Item No. **Report of the Head of Planning, Sport and Green Spaces**

Address 58 BRIDLE ROAD EASTCOTE

Development: Part two storey, part single storey front/side/rear extension involving demolition of existing side/rear elements

LBH Ref Nos: **18519/APP/2015/3980**

Drawing
Proposed Ground Floor Plan

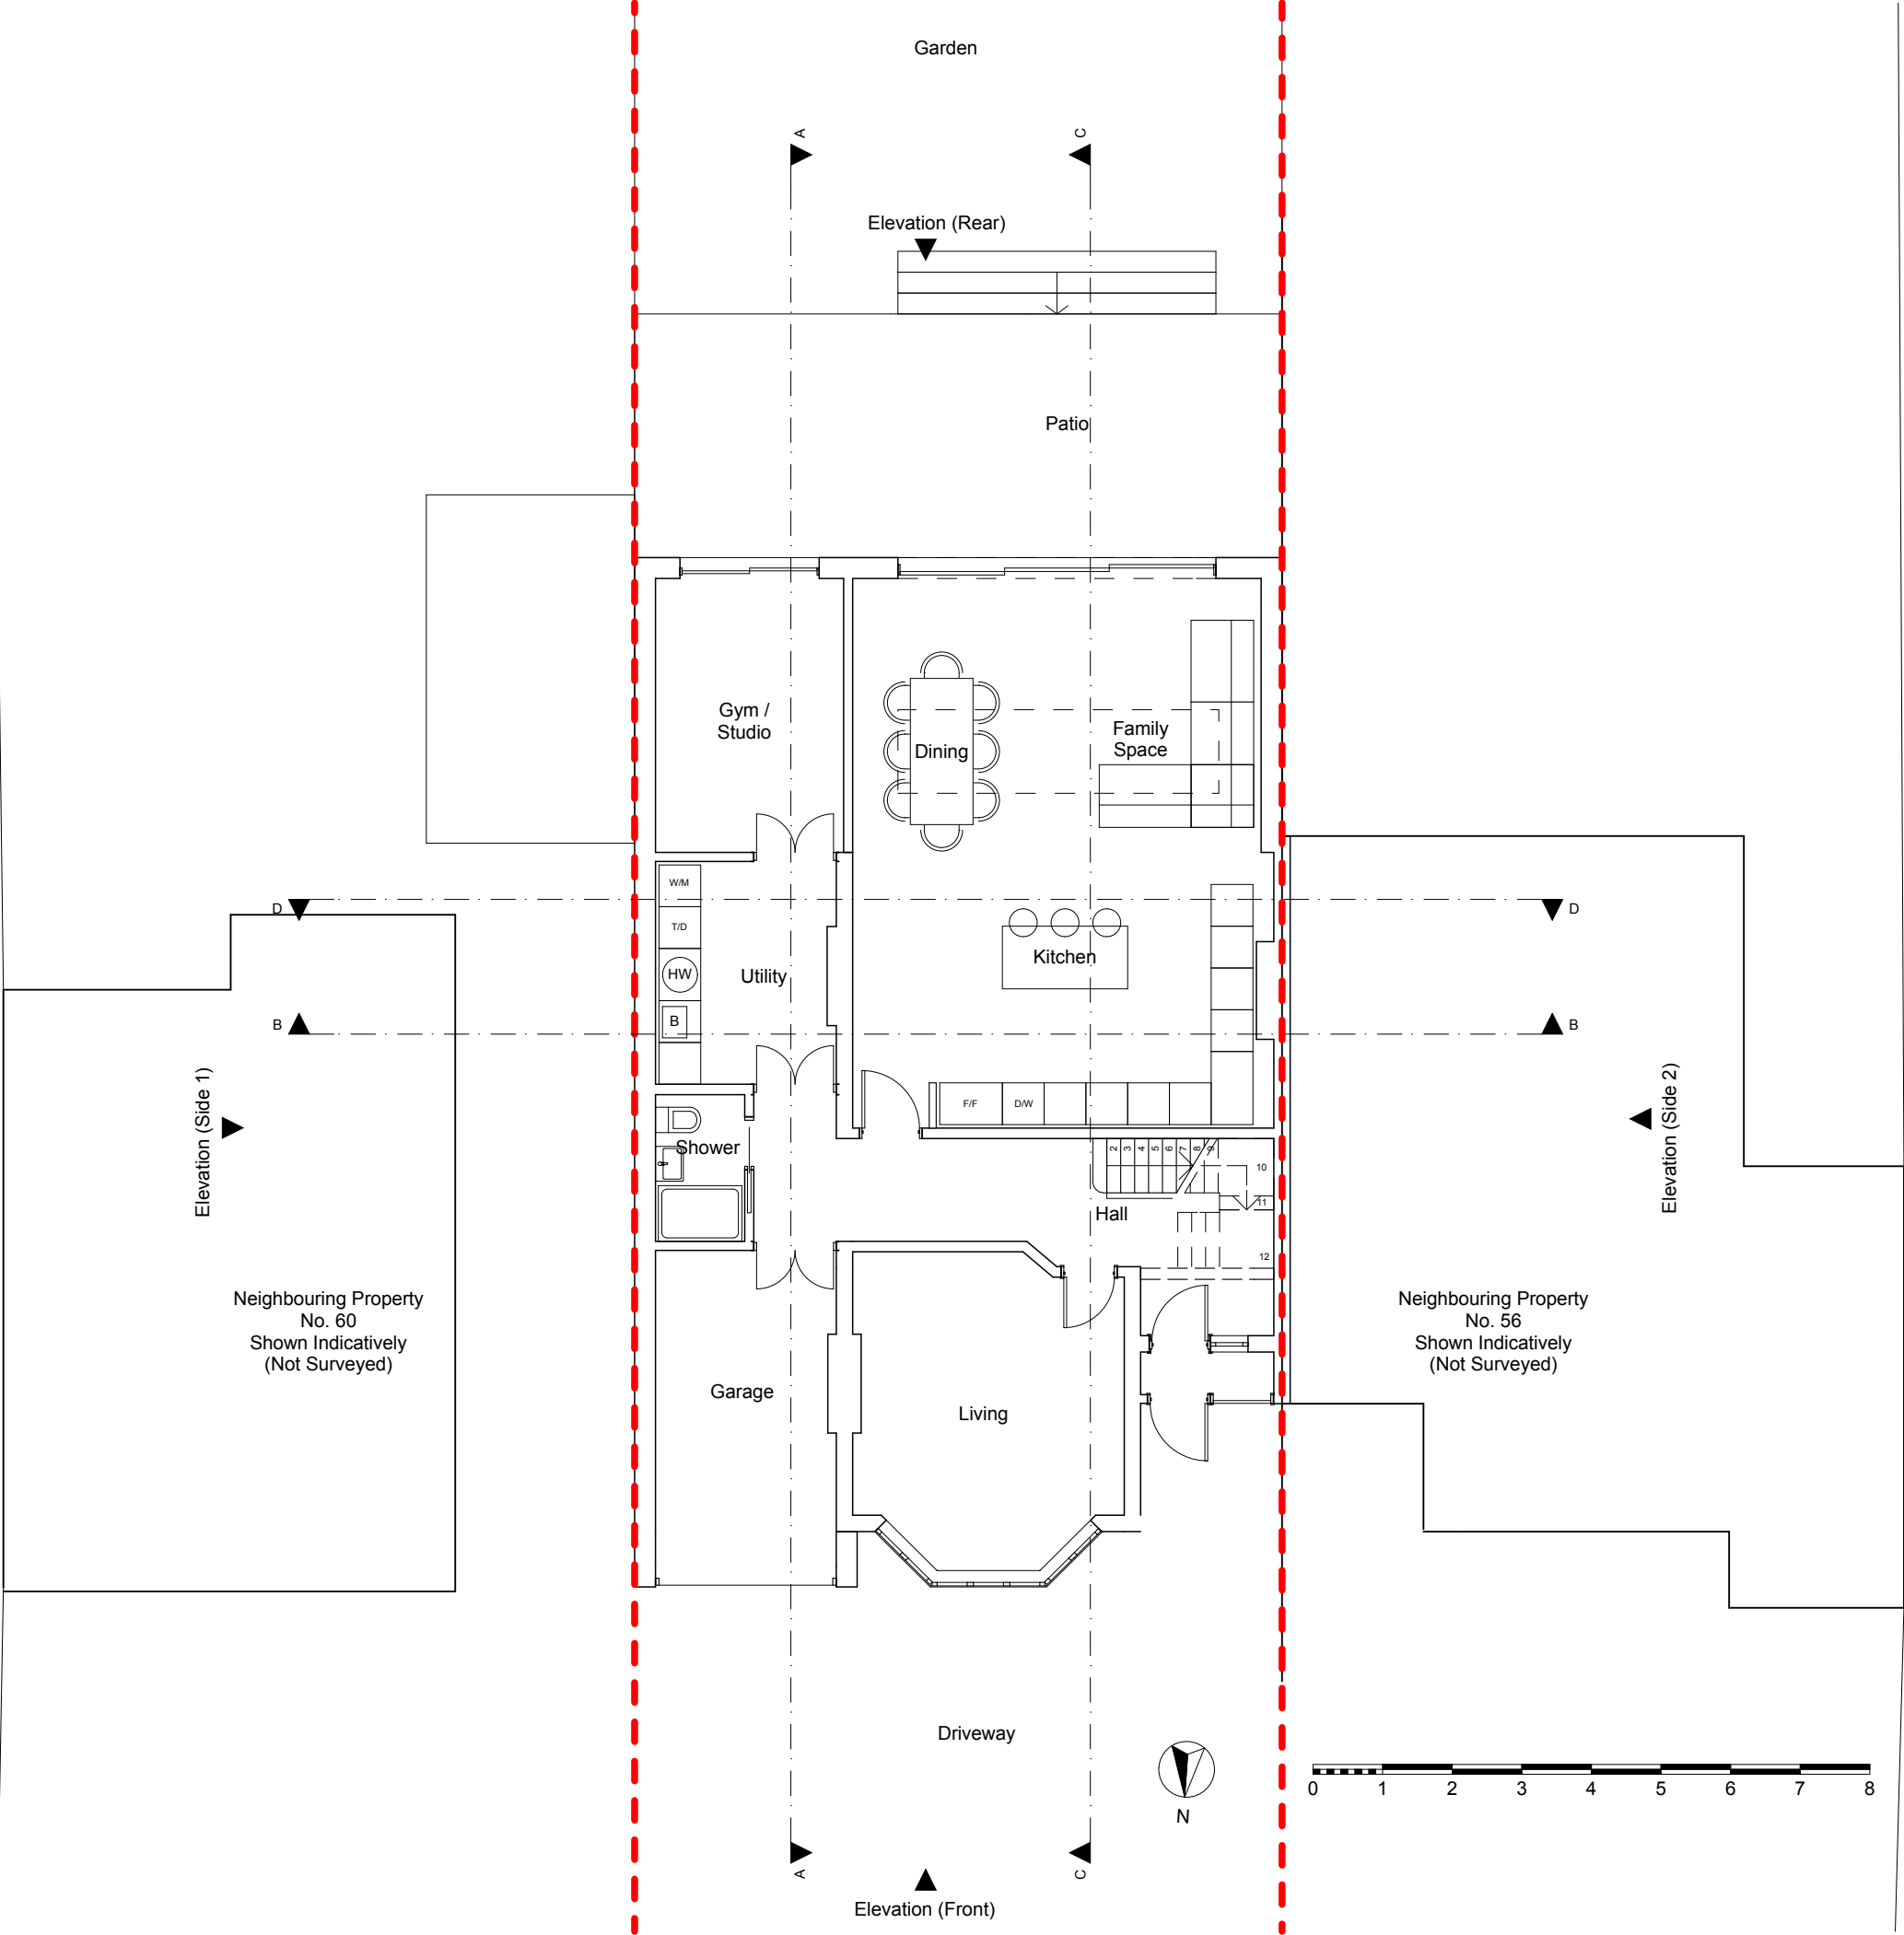
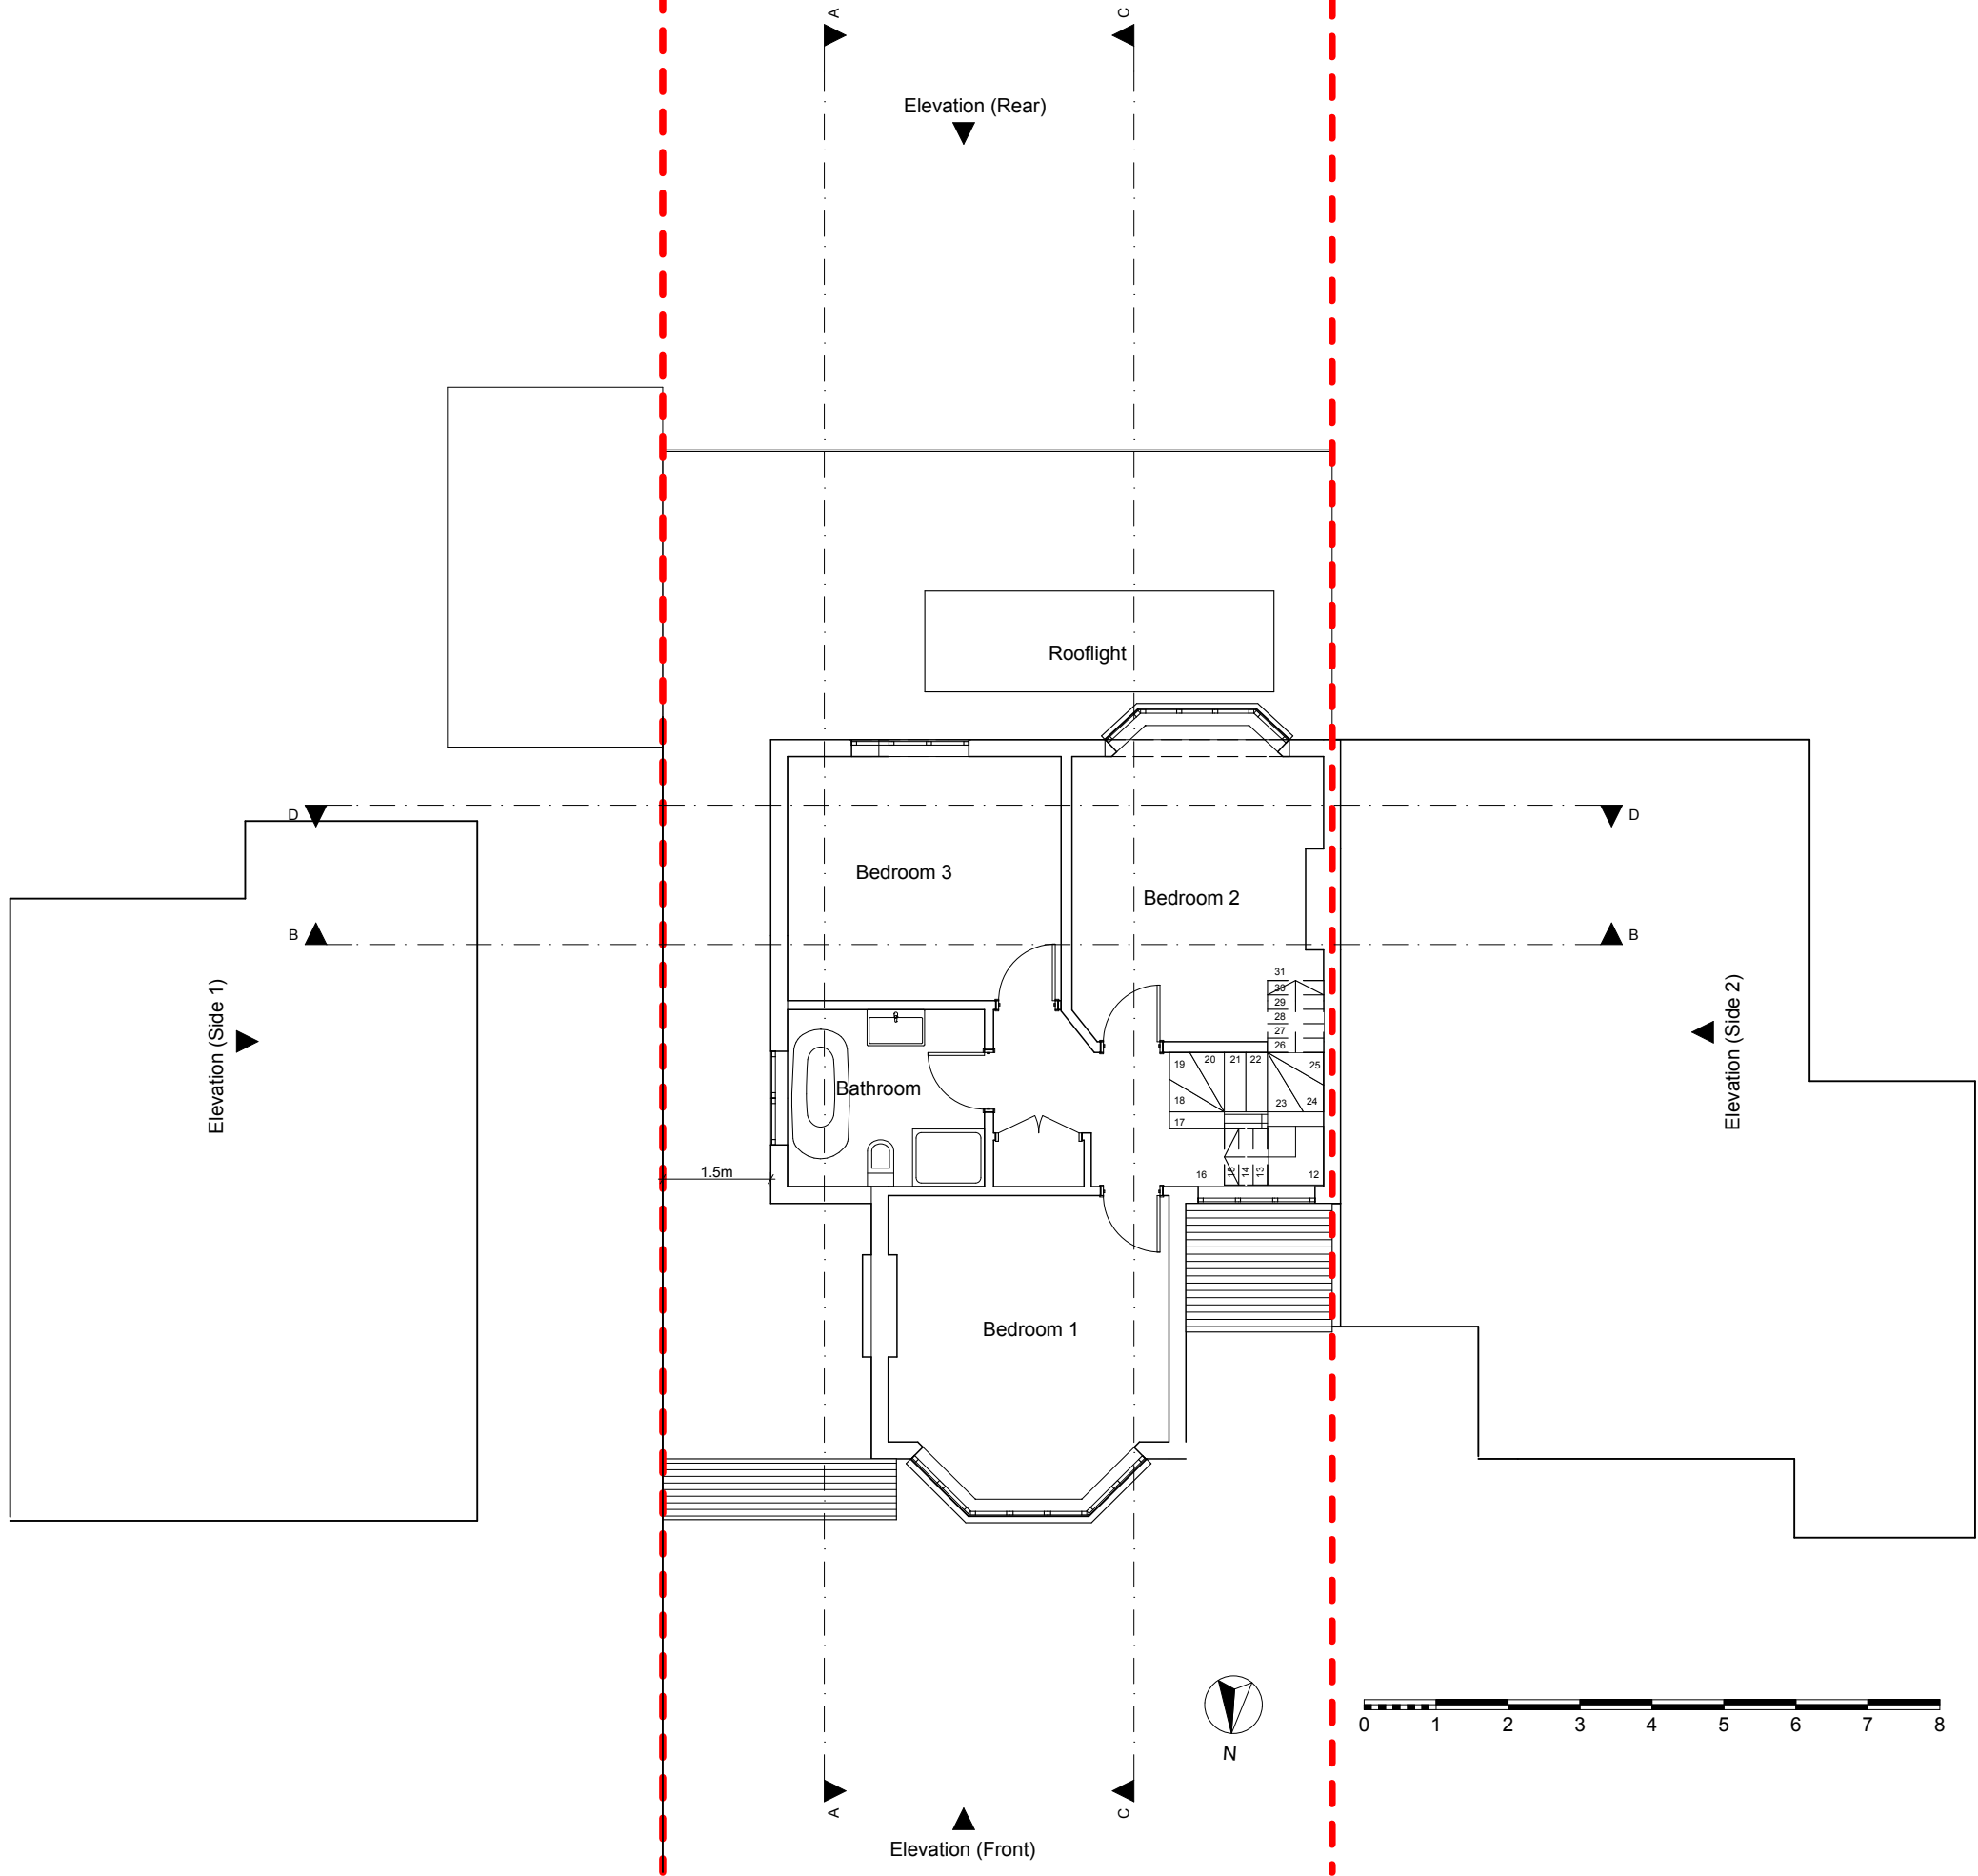
The ground floor of the proposed two storey side extension incorporates a new integral garage with forward projection of 1m to line up with the front gable bay projection. The ground floor of the side extension would be 2.85m wide and the single storey rear extension would abut the boundaries with both Nos. 56 and 60 at a depth of 3.9m. The extensions would be finished with a flat roof and parapet walls to the rear (height 2.95m, increasing to 3.2m at rear where the existing patio height drops) and finished with a dummy pitched roof (3.6m) to the front. It is instructive to note that the dimensions and form of the ground floor of the two storey side extension and single storey rear extension are the same as those approved under permission 18519/APP/2014/2078 (granted on 24/09/2014). It is also instructive to note that the approved extensions have not been built on the site.

less than half of the width of the existing dwelling (6.5m). The 1.5m set in of the first floor of the side extension from the eastern side boundary exceeds the required minimum of 1m. However, the lack of a set-in of the ground floor of the side extension from the side boundary and the absence of a set back of the ground floor from the front wall of the dwelling are such that the overall bulk of the two storey side extension would not result in a subordinate appearance to the dwelling. The unextended dwelling to the east at No.60 has not been extended to the side, thereby maintaining a considerable visual gap (particularly at upper level) between and around the adjacent end of No.60. It is considered that the inadequate set in of the ground floor of the proposed side extension from the boundary with No.60 is such that it would close up the visual gap, and result in a terracing effect in the event of a side extension being erected at that neighbouring dwelling. The proposed two storey side extension would therefore fail to respect the spacing character of the development context in the area. The inadequate set in from the side boundary and lack of a set back from the front wall would result in the two storey side extension constituting an ungainly and disproportionate addition to the existing dwelling. It is therefore considered that the proposed two storey side extension would significantly detract from the architectural integrity of the existing dwelling and the character and appearance of the area. It would therefore conflict with the requirements of Policy BE1 of the Hillingdon Local Plan: Part One - Strategic Policies (November 2012) and Policies BE13, BE15 and BE19 of the Hillingdon Local Plan: Part Two - Saved UDP Policies (November 2012) and the guidance contained in the HDAS SPD: Residential Extensions (December 2008).

The proposed two storey side extension, by reason of its size, scale, bulk, proximity and lack of adequate set back from the eastern side boundary with 60 Bridle Road, particularly at ground floor level, would result in a closing of the visually open gap between it and the neighbouring property, giving rise to a cramped form of development, which would be detrimental to the visual amenities of the streetscene and the surrounding area. The proposal is therefore contrary to Policy BE1 of the Hillingdon Local Plan: Part One - Strategic Policies (November 2012), Policies BE13, BE15 and BE19 of the Hillingdon Local Plan: Part Two - Saved UDP Policies (November 2012) and the adopted Supplementary Planning Document (SPD) HDAS: Residential Extensions (December 2008).
